**WELWYN HATFIELD BOROUGH COUNCIL
ASSISTANT DIRECTOR (PLANNING)**

DELEGATED APPLICATION

Application No: 6/2023/1497/LAWP
Location: Woodlands Well Road Northaw Potters Bar EN6 4BN
Proposal: Certificate of Lawfulness for the erection of side and rear extensions on the main dwelling and managers cottage
Officer: Ms Kirsty Shirley

Recommendation: Refused

Project Address	Woodlands, The Ridgeway, Hertfordshire EN6 4 BN
Project Description	Proposed Extensions
Drawing Title	PDR Application_Proposed Managers Cottage
Drawing No.	2755-1088
Rev.	P1

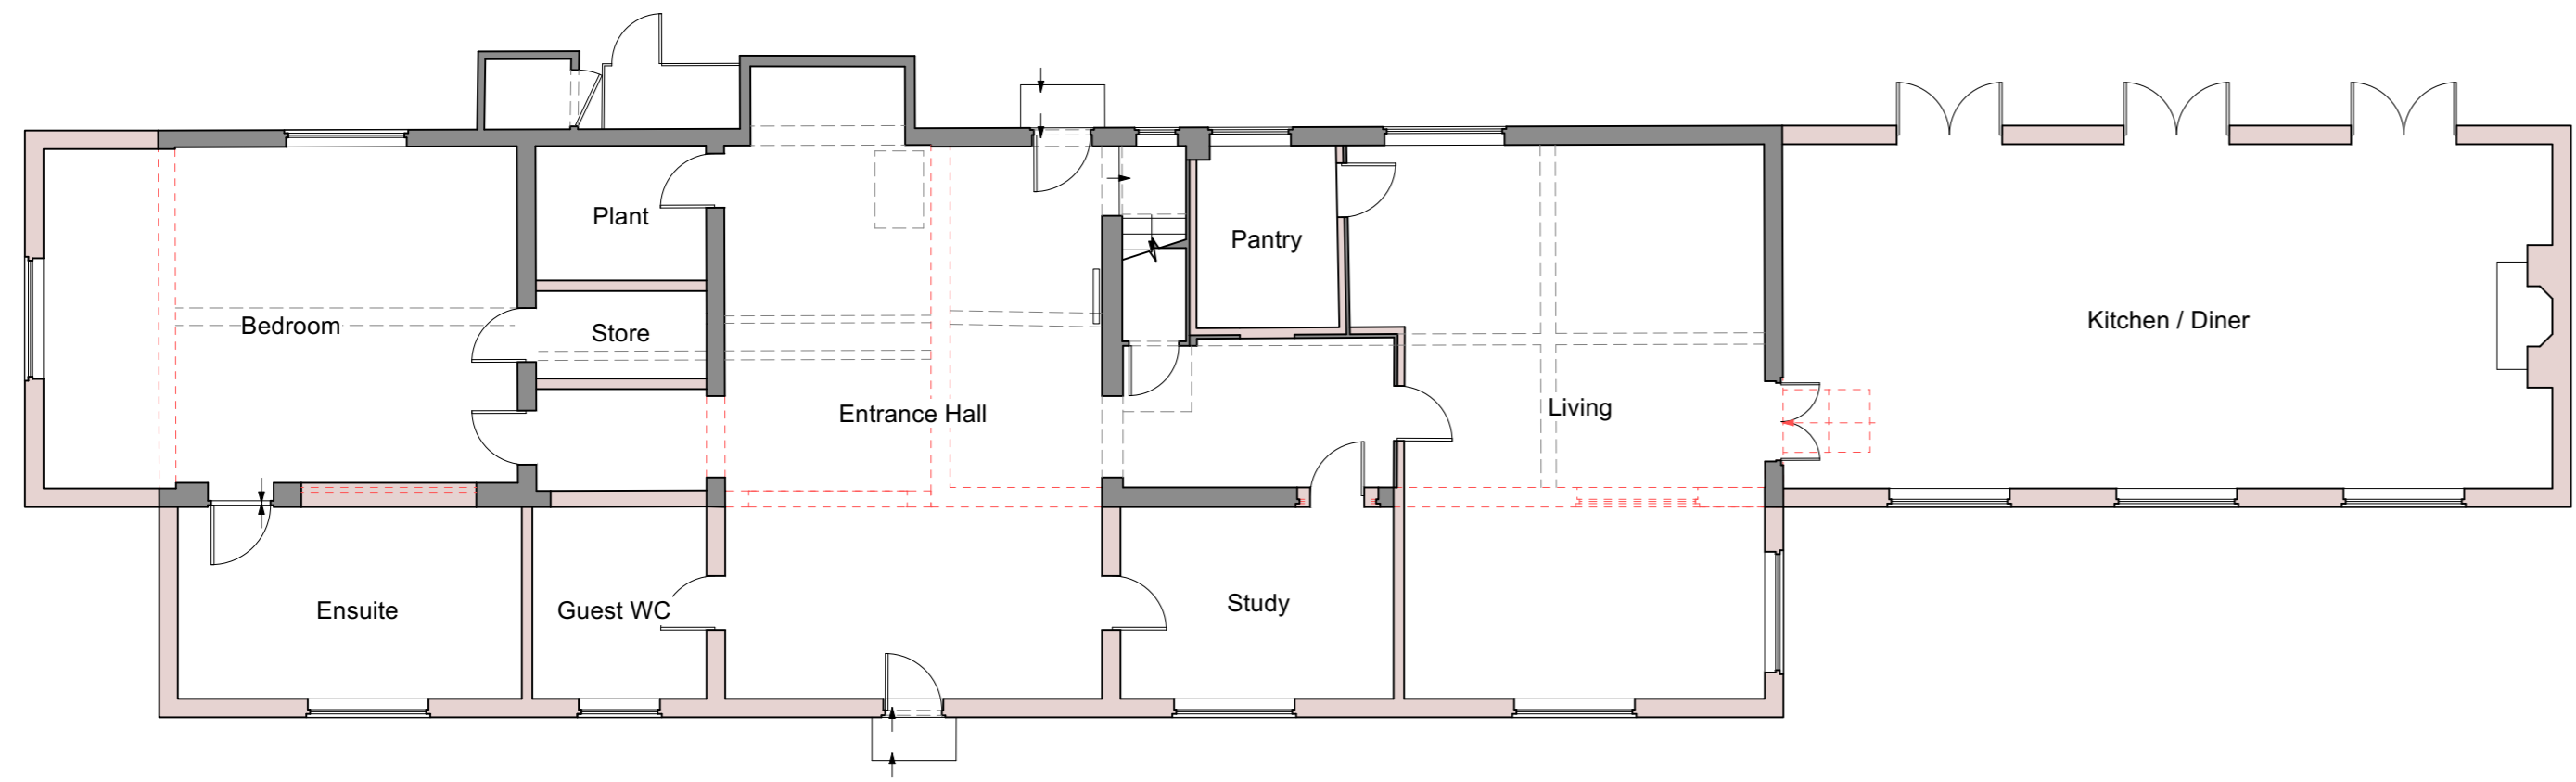
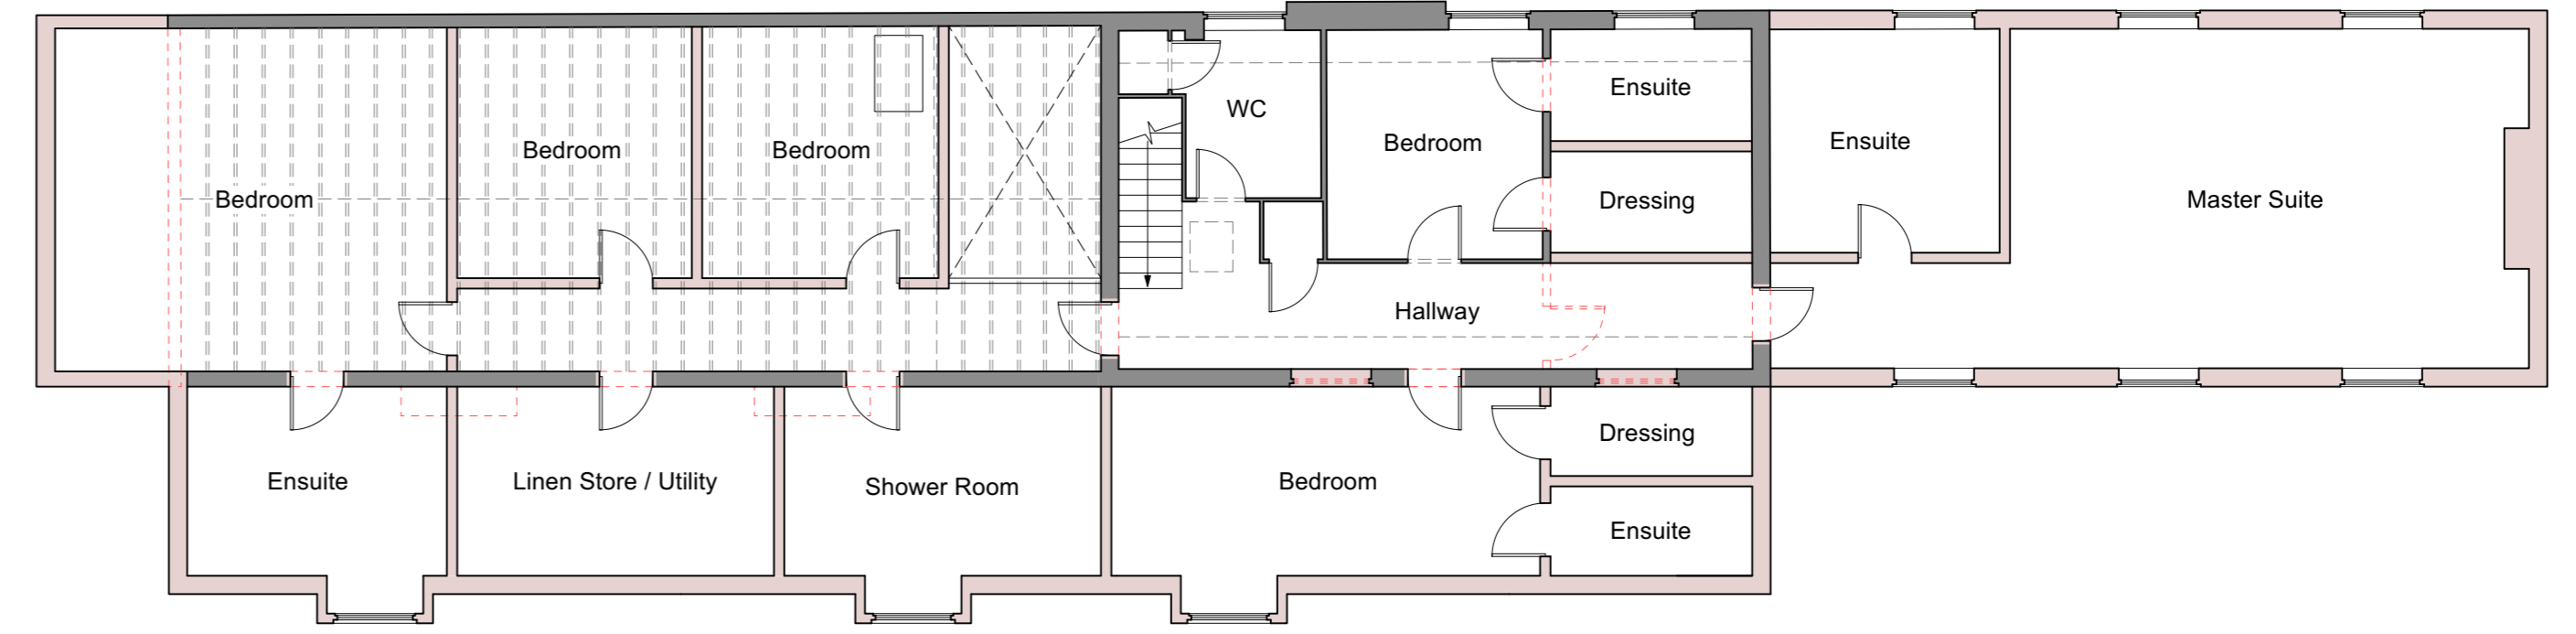
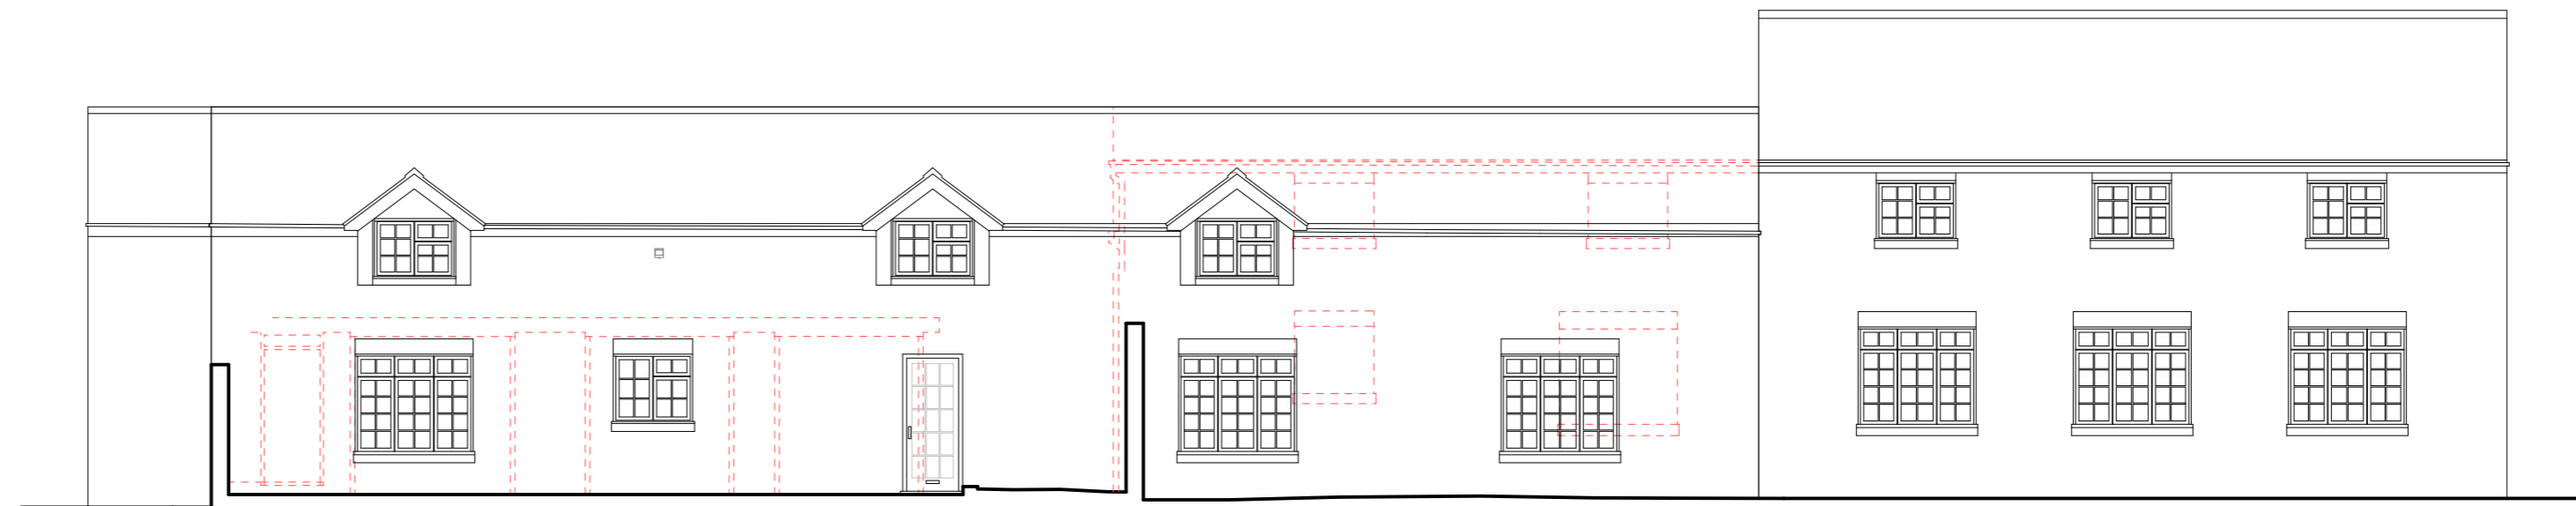
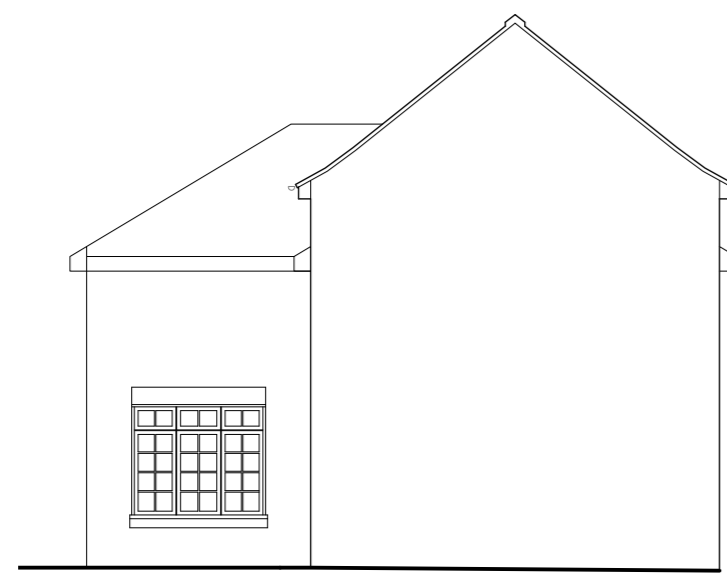
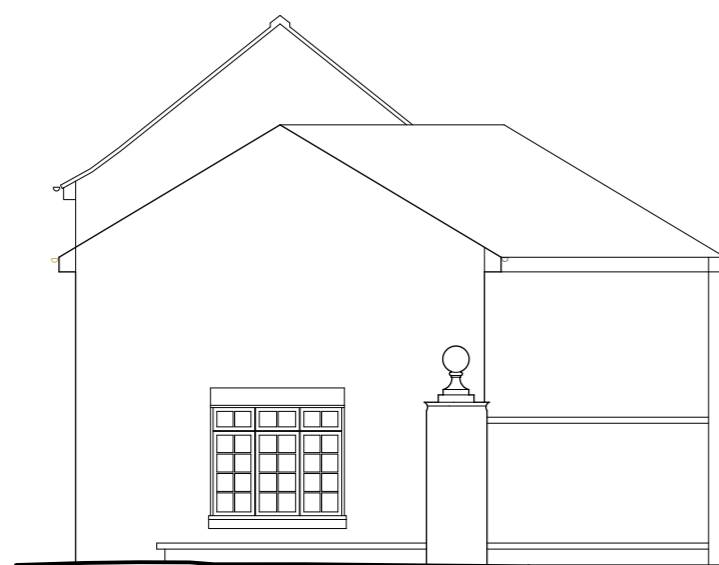
The proposal includes a two-storey side and rear extension for the Managers Cottage. The applicant states that the Managers Cottage is separate dwelling from the host dwelling.

The Managers Cottage is located approximately 20 meters from the host dwelling and shares the same vehicular access, grounds and garden area with no separate delineation. The Managers Cottage therefore has a clear functional link with the host dwelling.

A fact and degree judgement has to be made on the specific circumstances of each case. The key issue is whether the Managers Cottage is a separate planning unit. On the basis of information available, it is considered that the Managers Cottage is not a separate planning unit to the host dwelling. As such, the Managers Cottage does not benefit from the relevant permitted development by virtue of Schedule 2, Part 1, Class A of the Town and Country Planning (General Permitted Development) (England) Order 2015 as amended.

The Managers Cottage does not benefit from the relevant permitted development rights of Schedule 2, Part 1, Class A of the Town and Country Planning (General Permitted Development) (England) Order 2015 as amended.

| Drawing No. | 2755-1086 | Rev. | P1 |

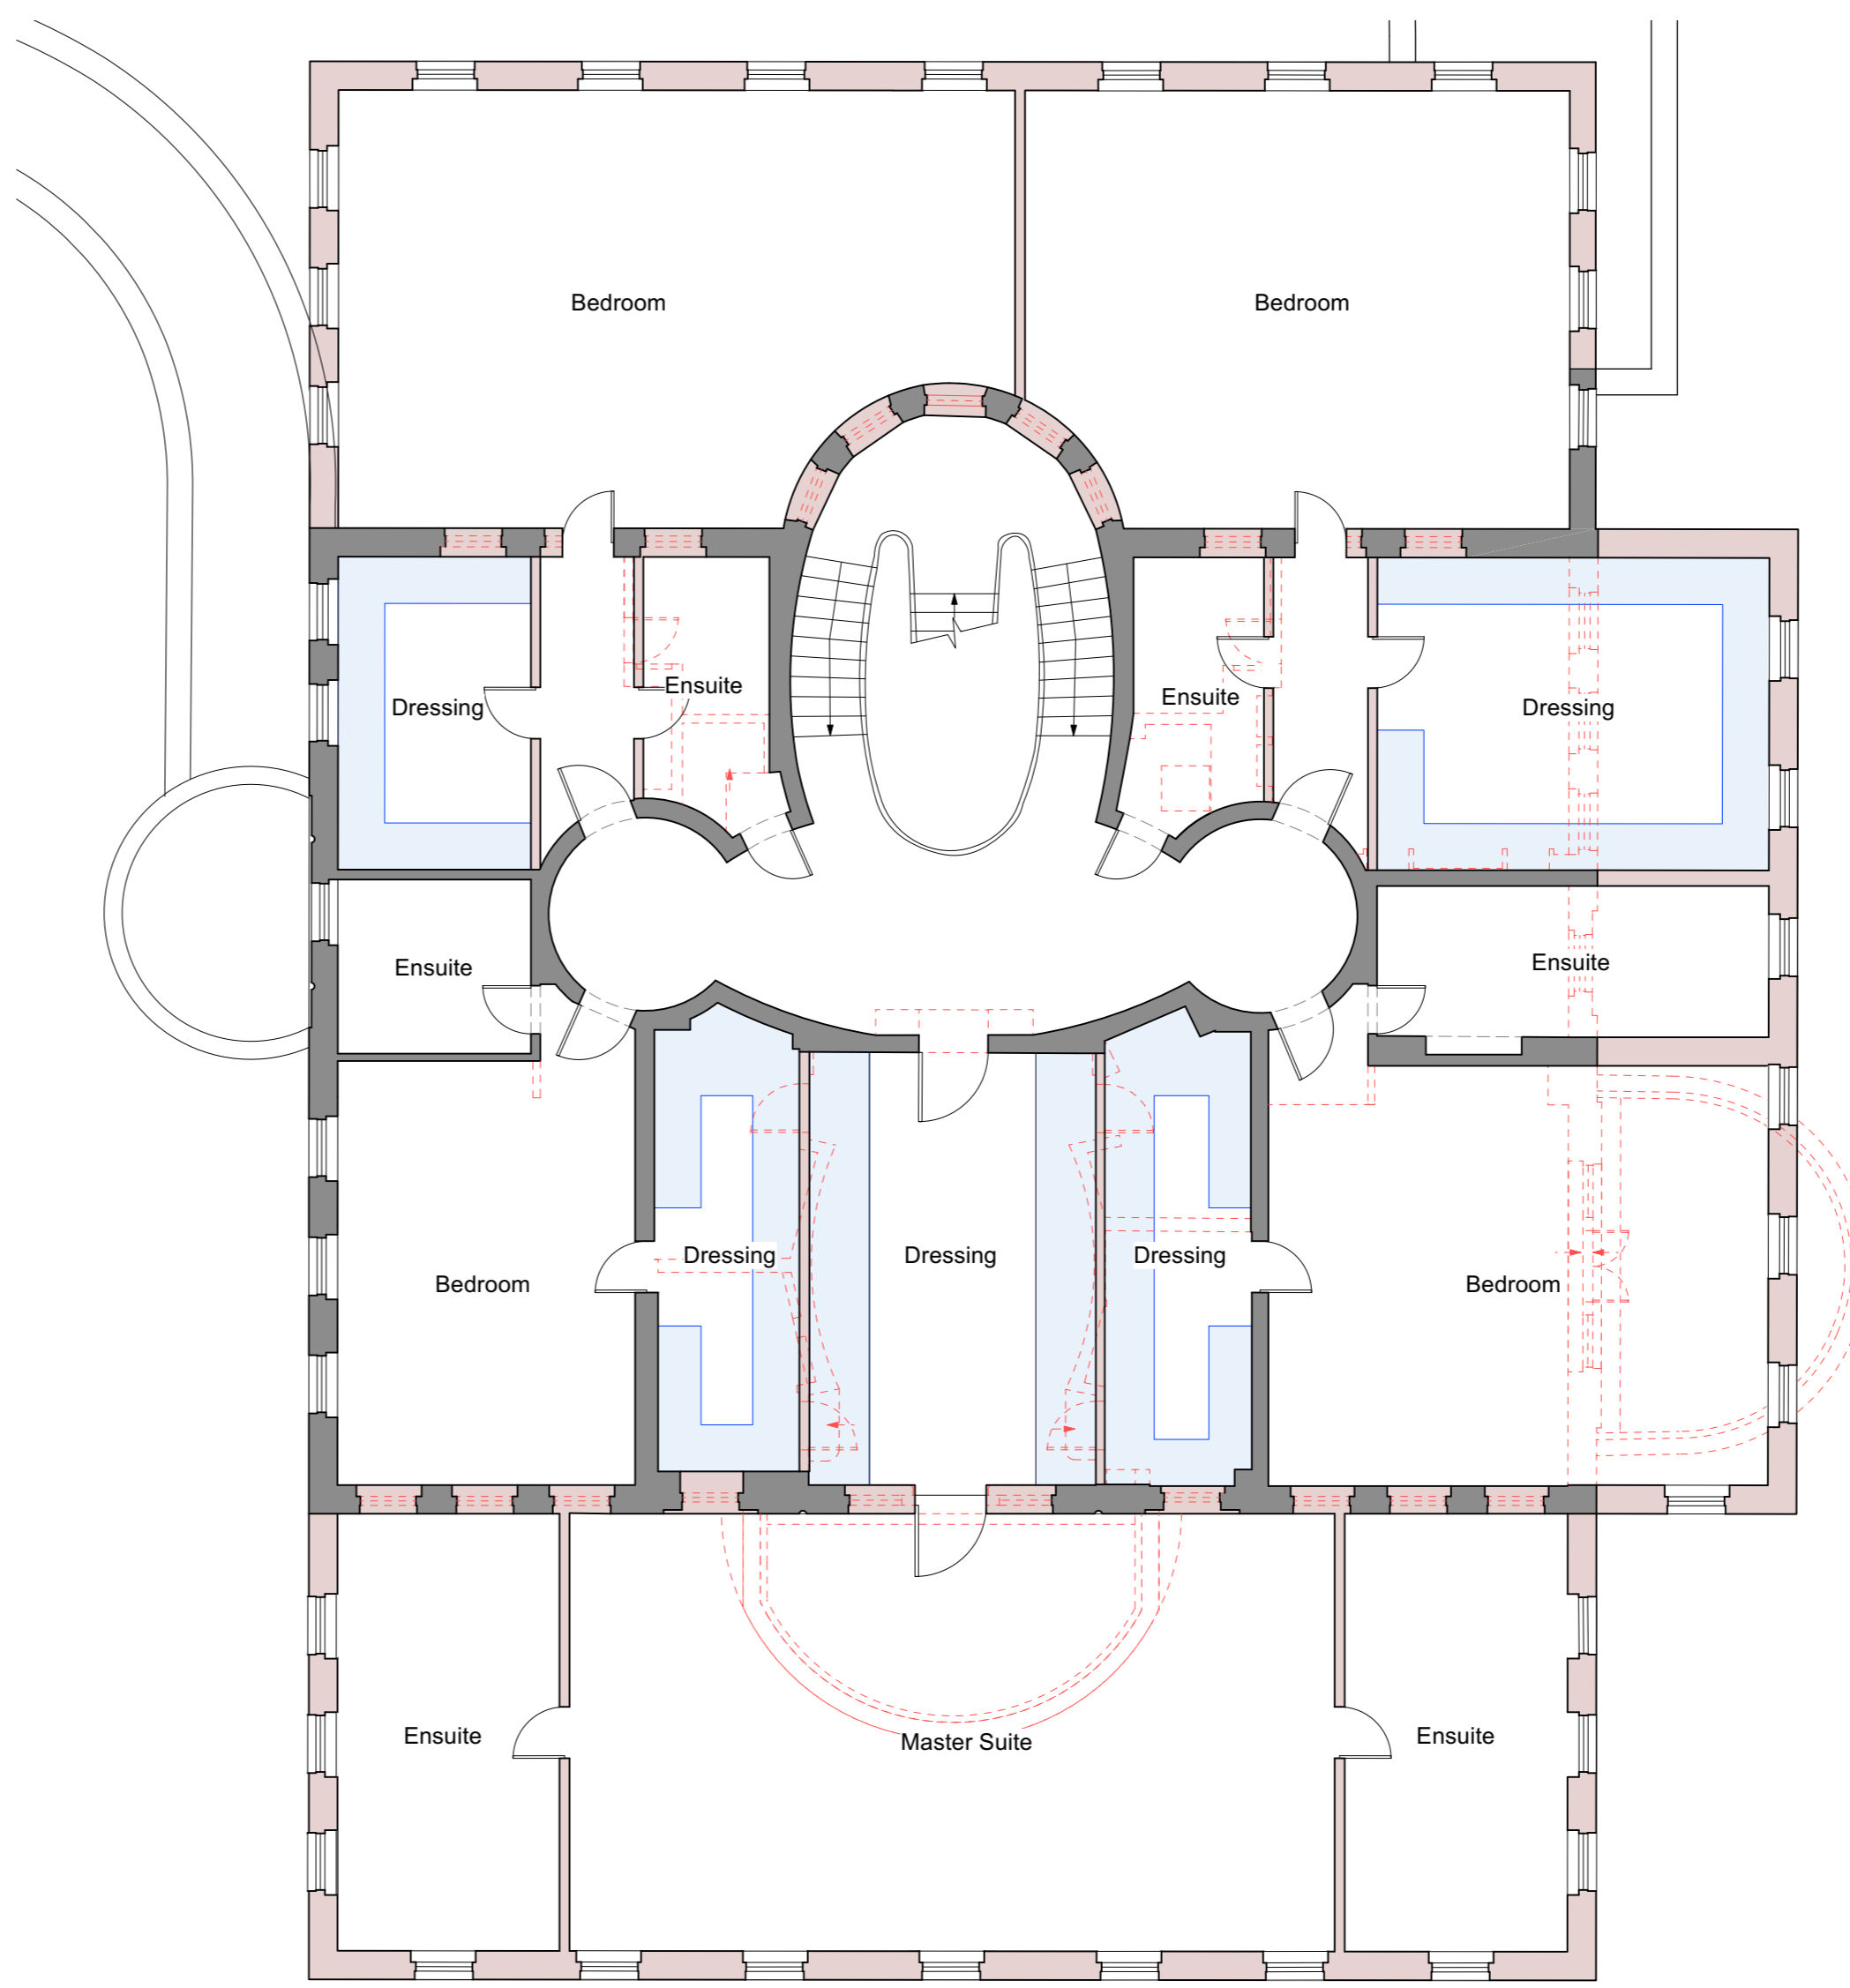
The main dwelling features curved projections within each elevation. These projections are considerable in size which allow for usable living space within the dwelling. While the Technical Guidance is only guidance, it makes it clear that any a wall forming a side elevation of a house will be any wall that cannot be identified as being a front or rear wall. Houses will often have more than two side elevation walls.

As a result of the east facing curved projection, the proposed east facing extension would infill an area between a side elevation and rear wall exceeding 4 metres in height and have more than a single storey, contrary to j (i) and (ii). The extensions on the north and south facing elevations would also exceed 4m in height and have more than a single storey, out of accordance with part j (i) and (ii).

Amendments to the Town and Country Planning (General Permitted Development) Order (GPDO) 2015 came into force on the 6th April 2017 and included an amendment to Part 1 Class A of Schedule 2. After paragraph A.1 (j), the following part has been inserted '*(ja) any total enlargement (being the enlarged part together with any existing enlargement of the original dwellinghouse to which it will be joined) exceeds or would exceed the limits set out in paragraph (e) to (j)*'. Therefore, where a proposed extension would be joined to an existing extension, some limitations and conditions apply to only the proposed extension, whereas other limitations and conditions apply to the combined structure. The south facing extension would be adjoined to an existing single storey structure which leads to guest accommodation. The south facing extension adjoining this single storey structure would result in the south facing extension to have a width greater than half the dwelling of the house, contrary to part j (iii) and ja.

The submitted information does not demonstrate that the materials used in exterior work would be of a similar appearance to those used in the construction of the exterior of the existing dwellinghouse, out of accordance with part A.3 (a).

The submitted information does not demonstrate that the upper floor windows in the side elevation would be obscure-glazed and non-opening, out of accordance with part A.3 (b) (i) and (ii).

The proposed development at the main dwelling would be contrary to part A.1 j (i) (ii) and (iii), part ja and part A.3 (a) and (b) (i) and (ii) of Schedule 2, Part 1, Class A of the Town and Country Planning (General Permitted Development) (England) Order 2015 as amended.
